**KIRKLEES METROPOLITAN COUNCIL
INVESTMENT & REGENERATION SERVICE**

Reference No: 2018/62/91621/W

Site Address: 35, Holly Road, Thornton Lodge, Huddersfield, HD1 3SE

Description: Erection single and two storey rear extension, front and rear dormers and front porch

Drawing Title.
Existing and Proposed Plans

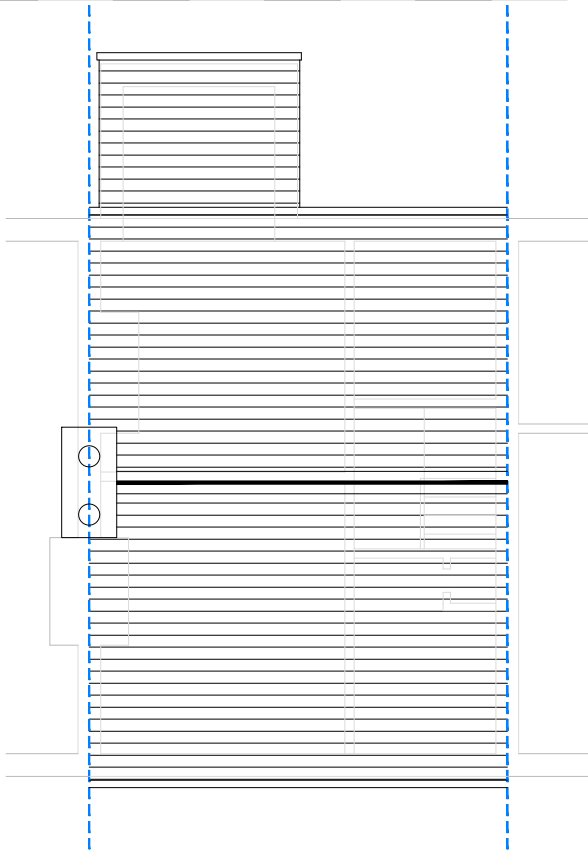
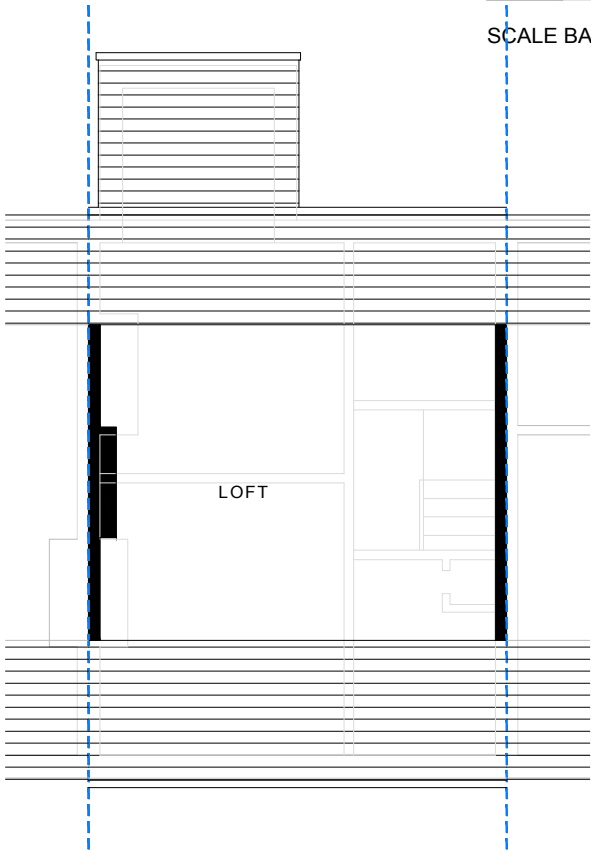
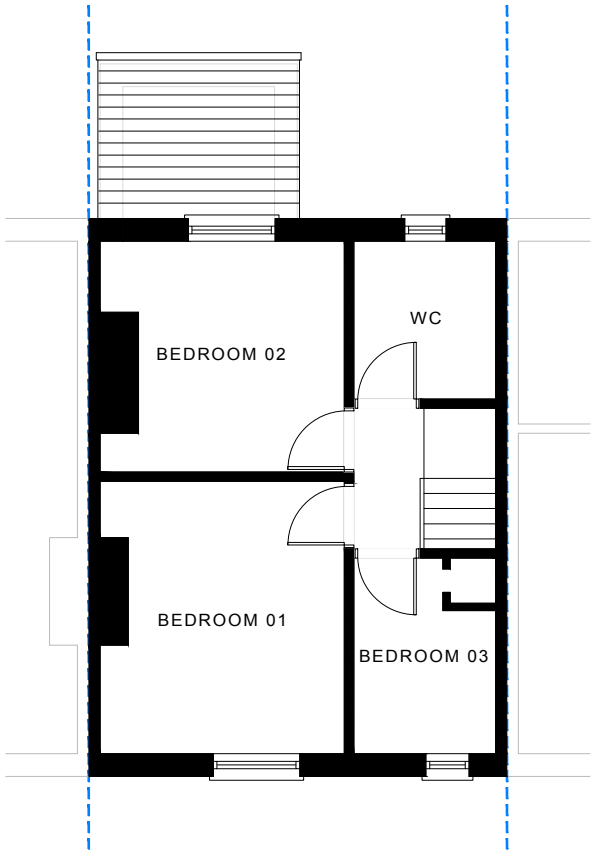
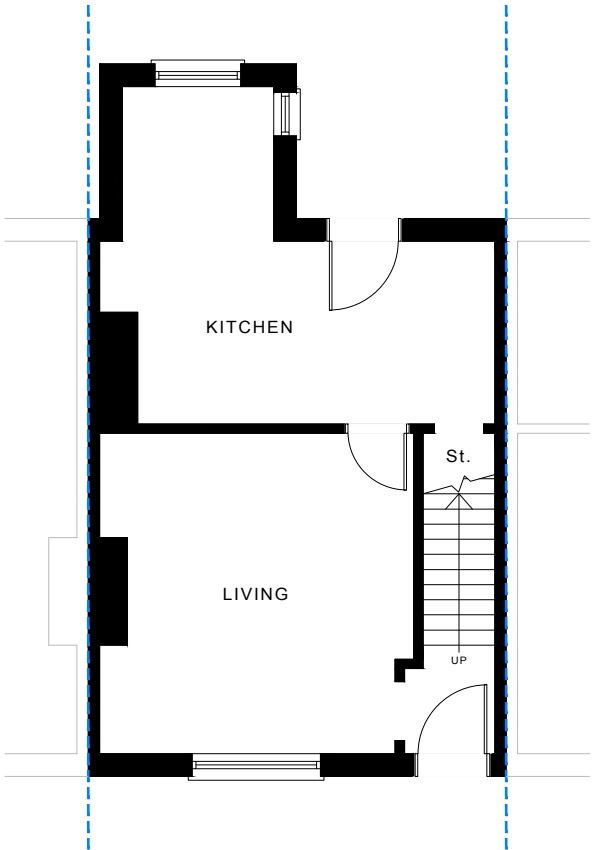
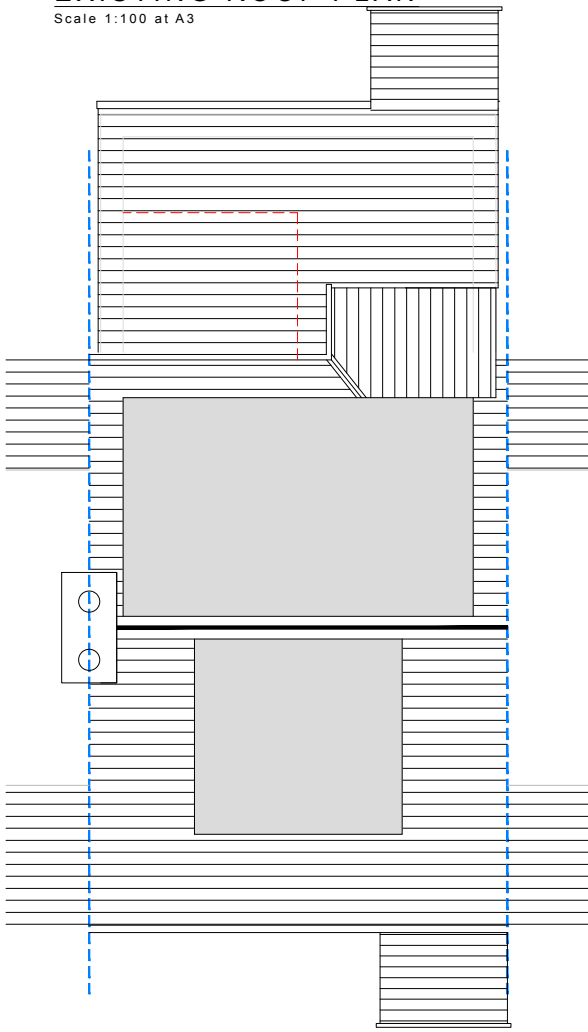
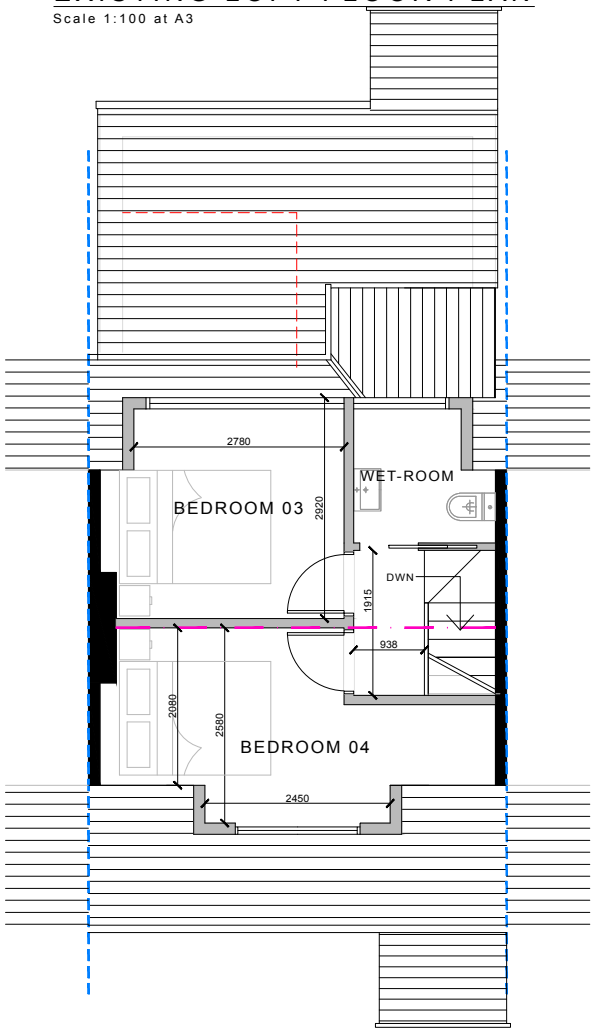
Following the site visit, concerns were raised in relation to a number of elements of the scheme and it was requested that the dormer extensions were reduced in size, especially the front dormer to ensure it would comply with current policy; the two storey extension to be amended to add either a shallow pitch or a cat slide roof to prevent the flat roof appearance; and it was also suggested that the rear extension be reduced to 3 metres to comply with current policy. Following these issues being raised, the scheme was altered to reflect the suggestions and amended plans submitted. The amended plans were received on 15th October 2018. The amended plans were not re-advertised as the proposals were smaller than originally submitted.

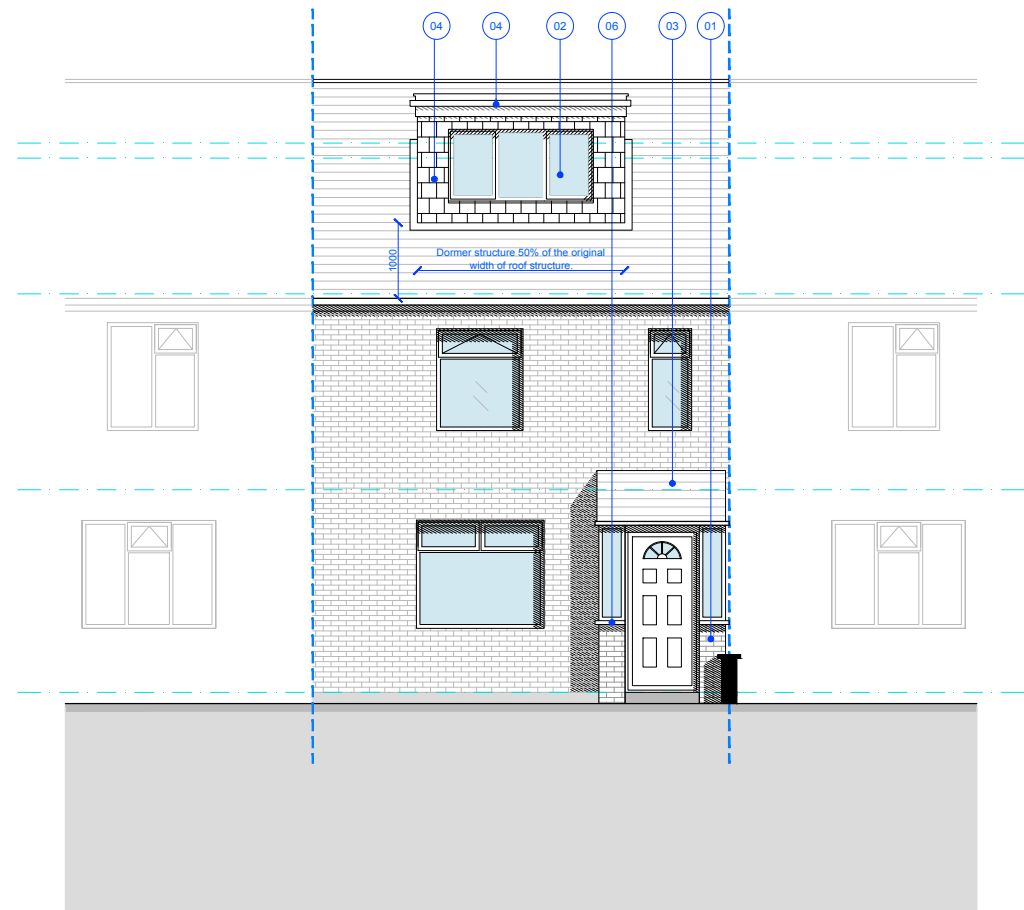
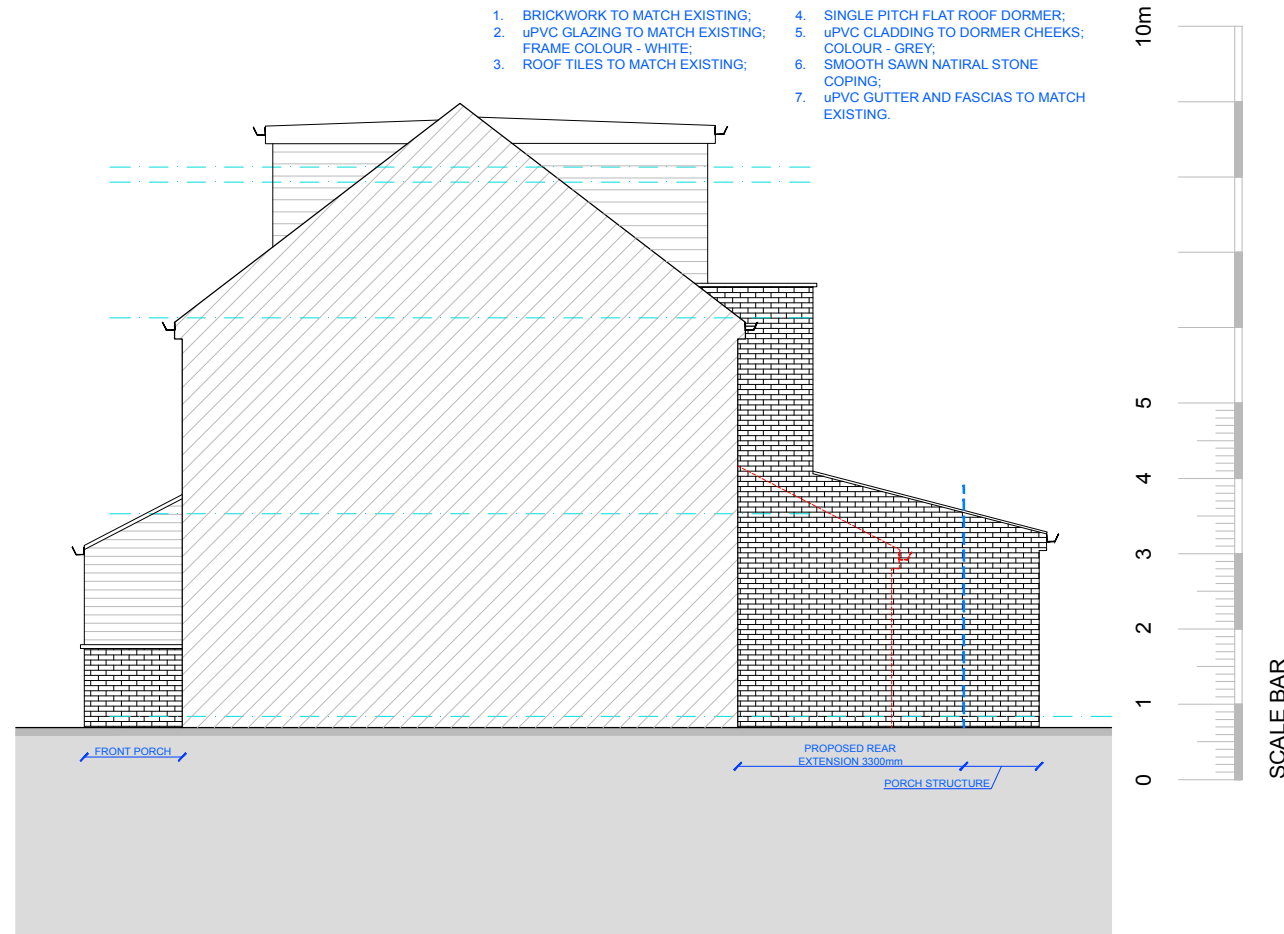
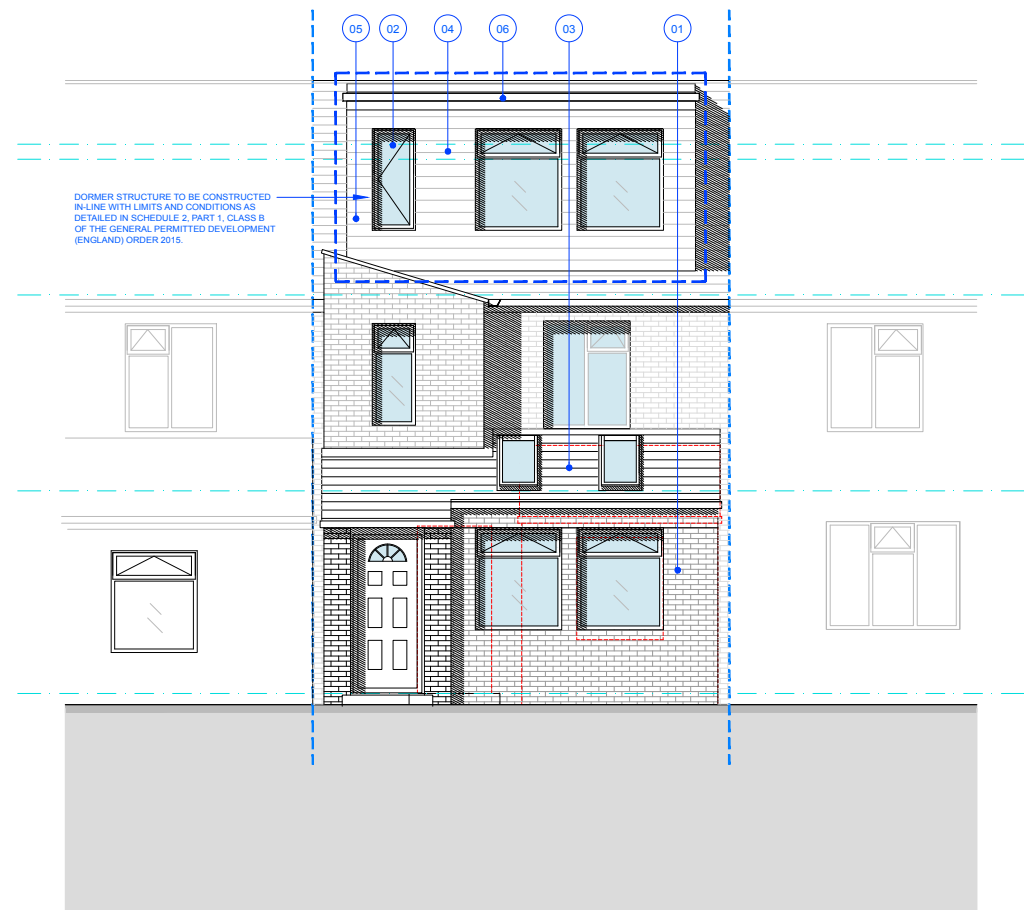
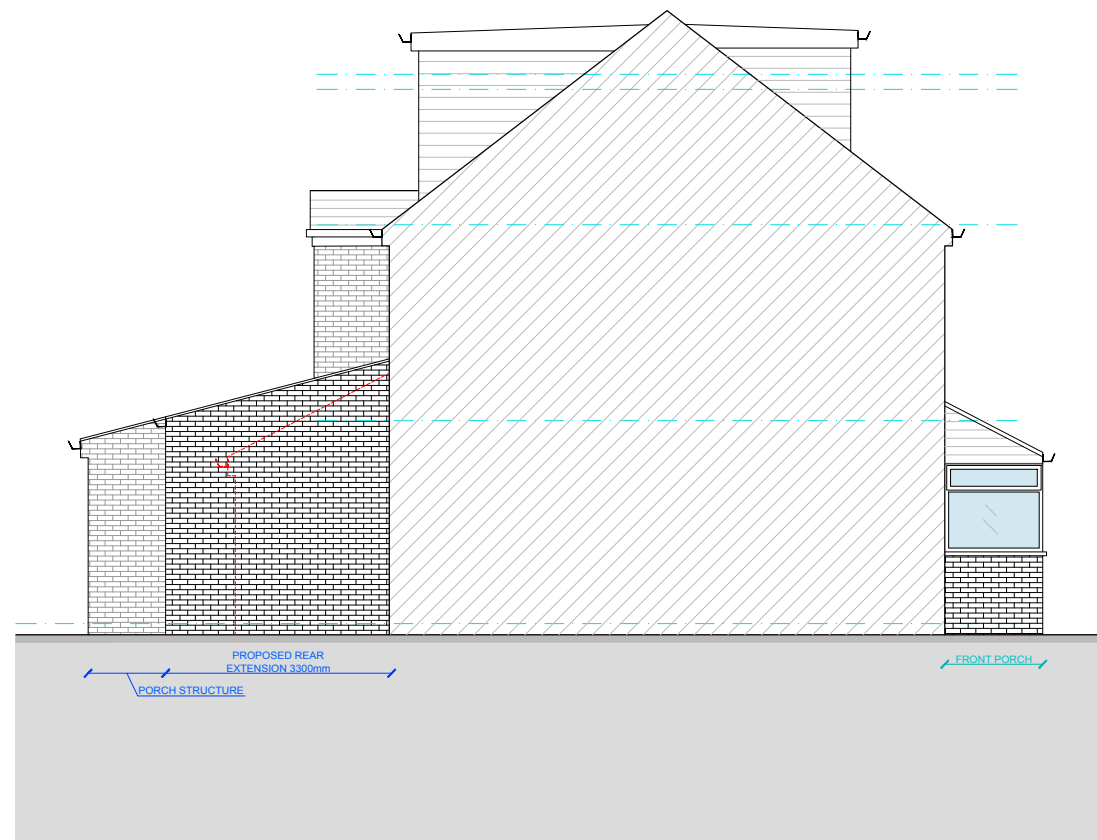
In terms of visual amenity, the dormer extension to the front of the building is a fairly uncommon feature within the Holly Road street scene with 2 small pitched roof dormers within the front roof slope of No. 66 Holly Road and with flat roof dormers located within the front elevation of 3 no. terraced properties within Moorbottom Road to the west of the application site. The proposed dormer would be centrally located no more than 50% of the width of the property and would ensure that the original roof is retained as the dominant feature and is clearly read as such. The plans suggest that the front dormer would be tile hung however this is not listed on the proposed construction materials. Therefore, to ensure that the dormer is in keeping with the host property, this can be conditioned be tile hung to minimise its impact. The rear elevation would be larger than the proposed front dormer and would be uPVC clad with a grey finish which is considered to be acceptable due to being at the rear of the property. Whilst the front dormer would not be strictly compliant with Policy BE15 in terms of the dormer not being set down from the ridge of the dwelling by 0.5 metres it is considered that the dormers are acceptable for the reasons given above.

5. The front dormer hereby approved shall be tile hung to the front & cheeks to harmonise with the roof of the host property.
